Oifig na
nOibreacha Poiblí
Office of Public Works

O.P.W Ref No. 219-2024

Case Ref. PAX91.323448 Permission for windfarm located in the Townlands of Garrane, Ballynagoul, Greggane and Chareville, County Limerick

Proposed Water Crossing WC01

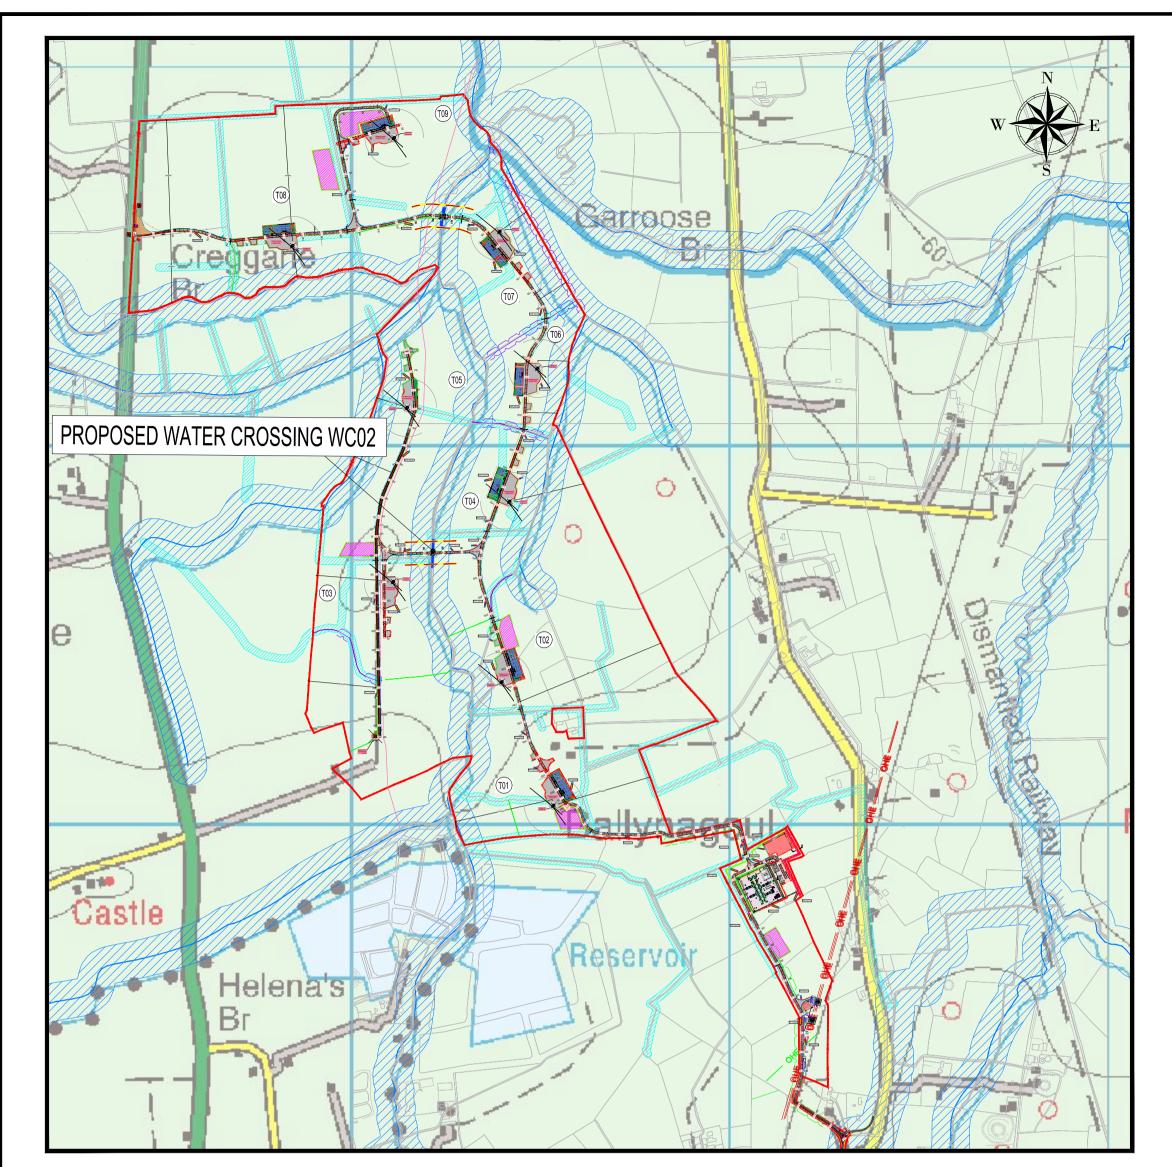
The proposal identifies a number of new bridges and culverts. Any new culverts or bridges (or modifications to any existing culverts or bridges) that are required to cross watercourses as part of the development or that form part of any proposed or existing access roads to serve or access the development; you should be aware that these require consent from the Commissioners of Public Works. This is a requirement of Section 50 of the Arterial Drainage Act of 1945 as amended.

Please note that, in the context of seeking consent under Section 50, the current required design standard for bridges or culverts is based on the flood flow with an annual exceedance probability (AEP) of 1% (often referred to as the 100 year flood), increased by 20% to cater for the effects of climate change. Bridges or culverts are required to be able to convey this design flood without significantly altering the hydraulic characteristics of the watercourse – further details on this issue are available in the brochure and can be clarified depending on the circumstances of any particular proposed bridge or culvert.
